KIRKLEES METROPOLITAN COUNCIL INVESTMENT & REGENERATION SERVICE

DELEGATED DECISION TO DETERMINE PLANNING APPLICATIONS

Reference No:	2026/62/91855/E
Site Address:	12, Birkdale Road, Dewsbury, WF13 4HH
Description:	Demolition of existing rear extension and erection of single storey rear extension (within a Conservation Area)
Recommending Officer:	Ellen Gilbert

DECISION – CONDITIONAL FULL PERMISSION

Drawing Title
Proposed Elevations

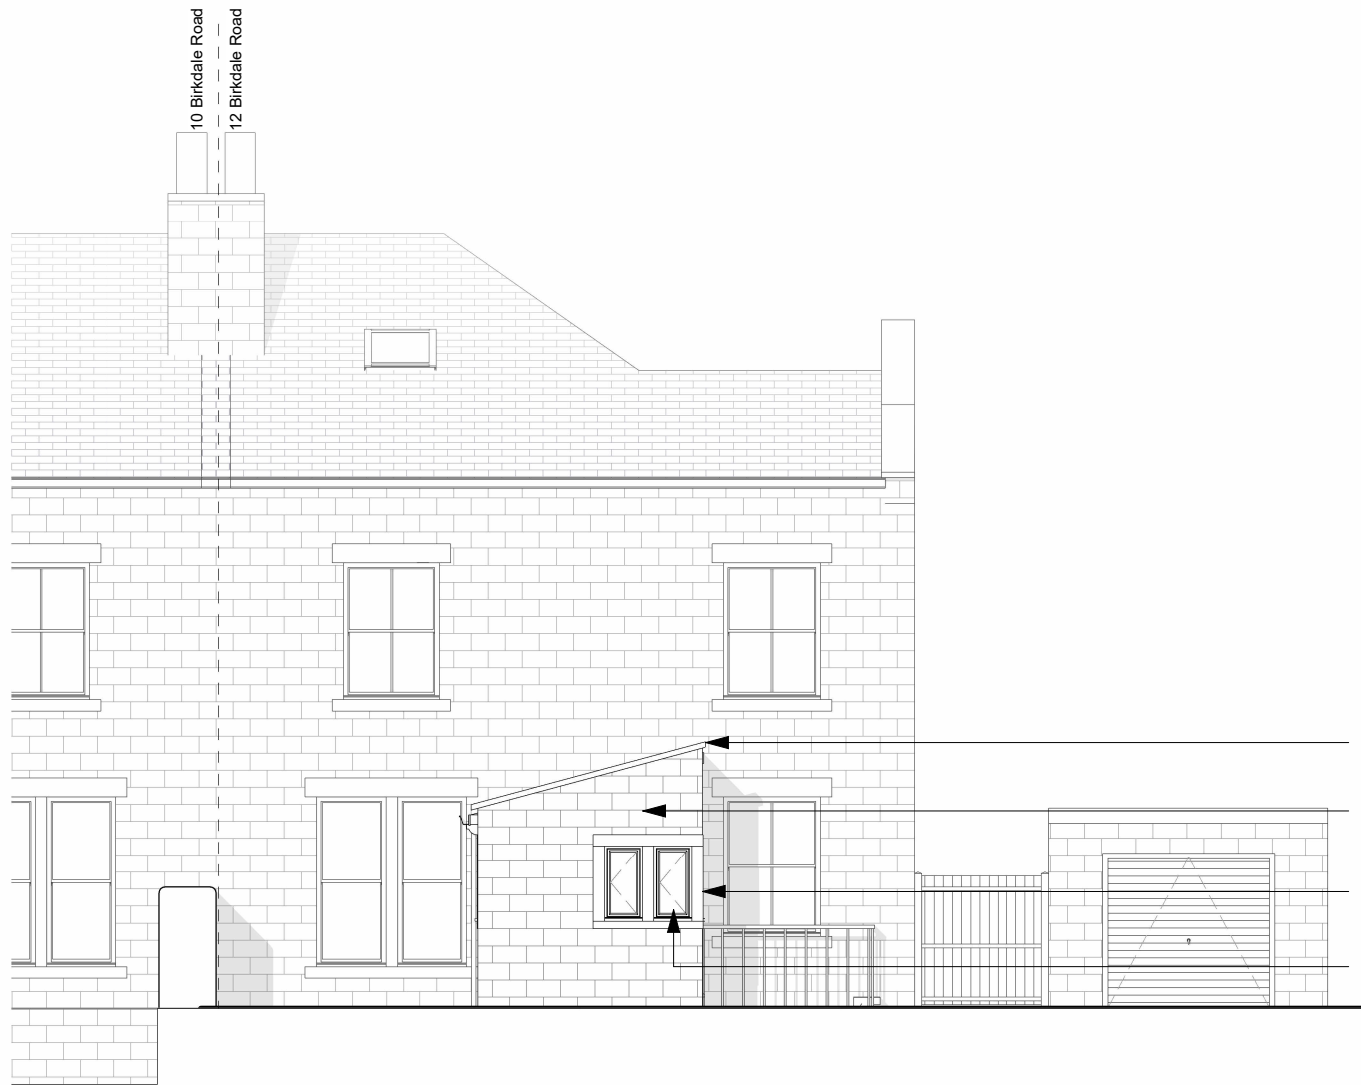
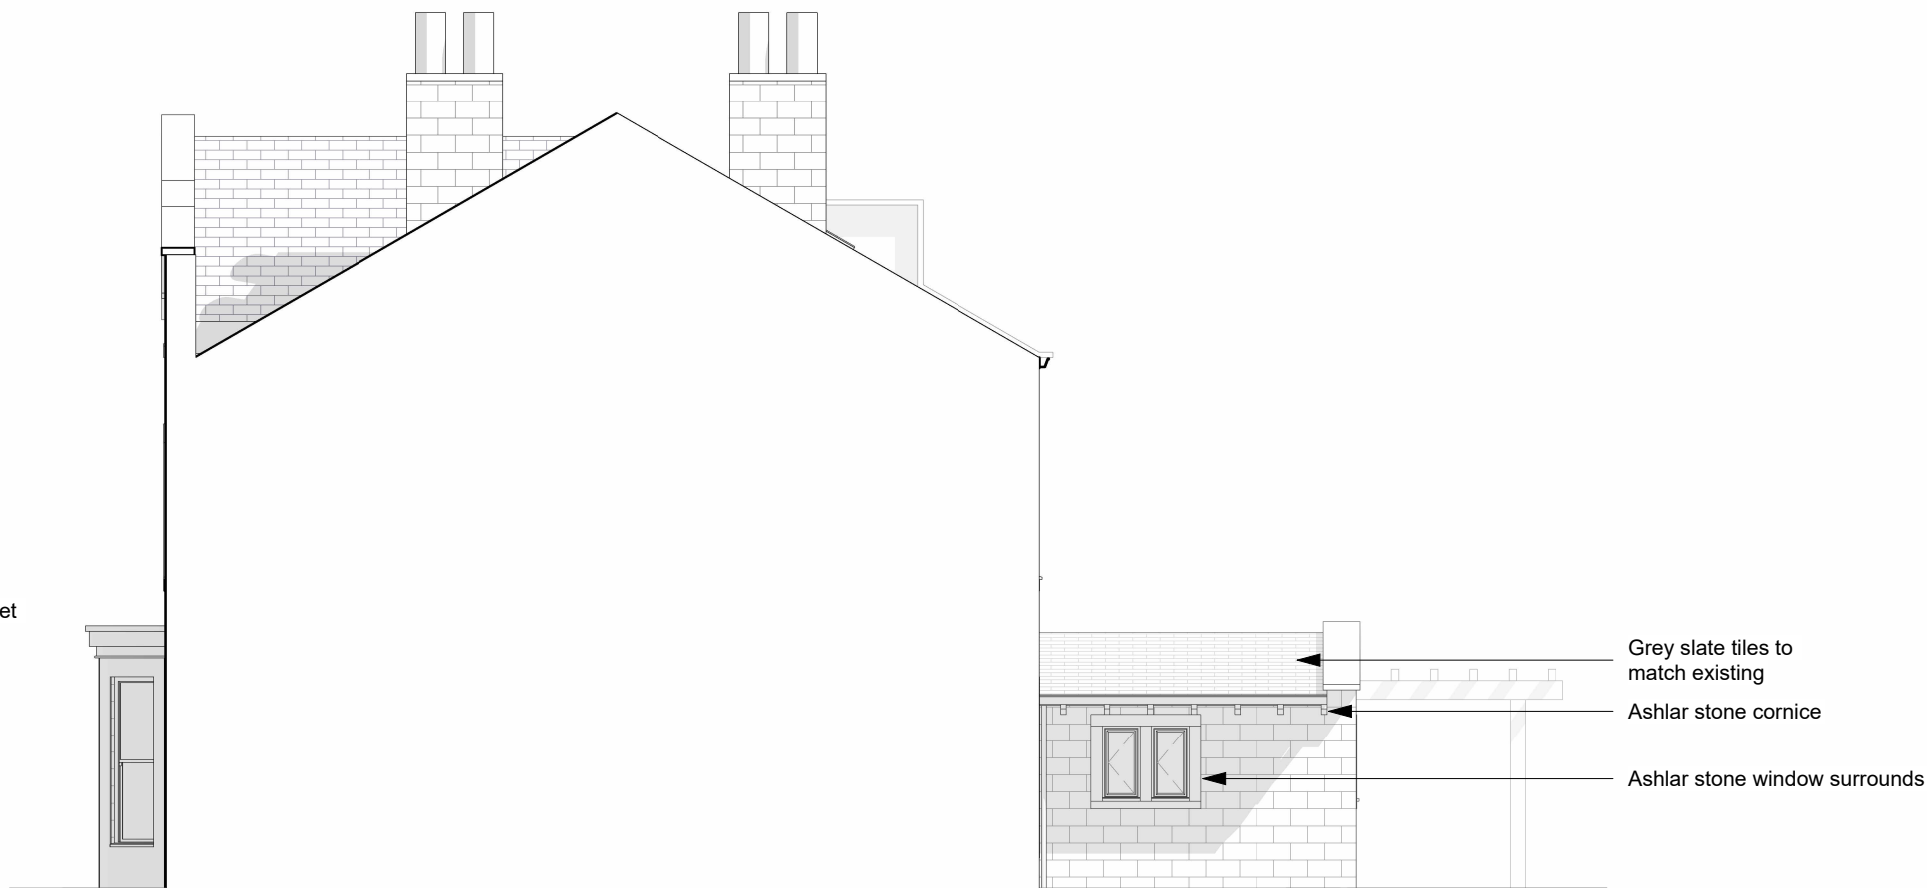
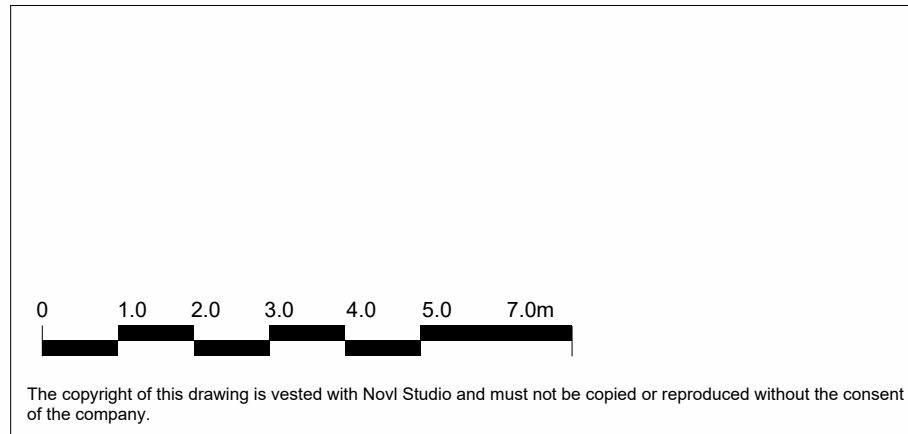
The applicant is seeking planning permission for the demolition of existing rear extension and erection of single storey rear extension (within a Conservation Area). The extension will feature a lean-to pitched roof with grey slate tiles and ashlar stone parapet coping. The proposed will be constructed out of coursed natural stone to match the host dwelling and in terms of openings, the extension will also feature 7 windows to feature ashlar stone surrounds, will retain the existing position of the doorway.

Paragraphs 5.1, 5.2 and 5.6 of the House Extensions & Alterations SPD is of relevance here, stating that single storey rear extensions should be in keeping with the original house, retain an adequate amount of garden and use appropriate materials which match or are in similar appearance to the original house. In the case of this application, the subject of this report, the proposed replaces a painted wooden structure which heavily contrasts with the stonework and Victorian architectural character of the host dwelling. The proposed would be constructed using natural stone to match the existing and grey slate tiles; the use of which will be made acceptable through the granting of conditions. Ashlar coping window surrounds are also complimentary in character, drawing upon the heavy stonework which characterises the property and surrounding dwellings.

KC Conservation and Design were informally consulted and raised no objection subject to conditions. It is recommended that all external stonework and roofing slate match the existing materials in terms of type, colour and finish. Proposed windows and doors should be installed with a minimum recess of 150mm from

the external face of the wall to maintain the traditional appearance of the building. In addition, lime mortar pointing should be used and finished flush or slightly recessed to preserve the character and significance of the property. These requirements are to be secured by conditions.

3. Notwithstanding the plans submitted the external walls and roofing materials of the development hereby approved shall in all respects match those used in the construction of the existing building and be retained thereafter.

4. Notwithstanding the details shown on the approved plans, all new windows and external doors shall be installed with a minimum recess of 150mm from the outer face of the wall and retained as such thereafter.

5. All repointing and pointing associated with the development shall be carried out using a lime-based mortar. The finished pointing shall be either flush or slightly recessed and shall be retained thereafter.
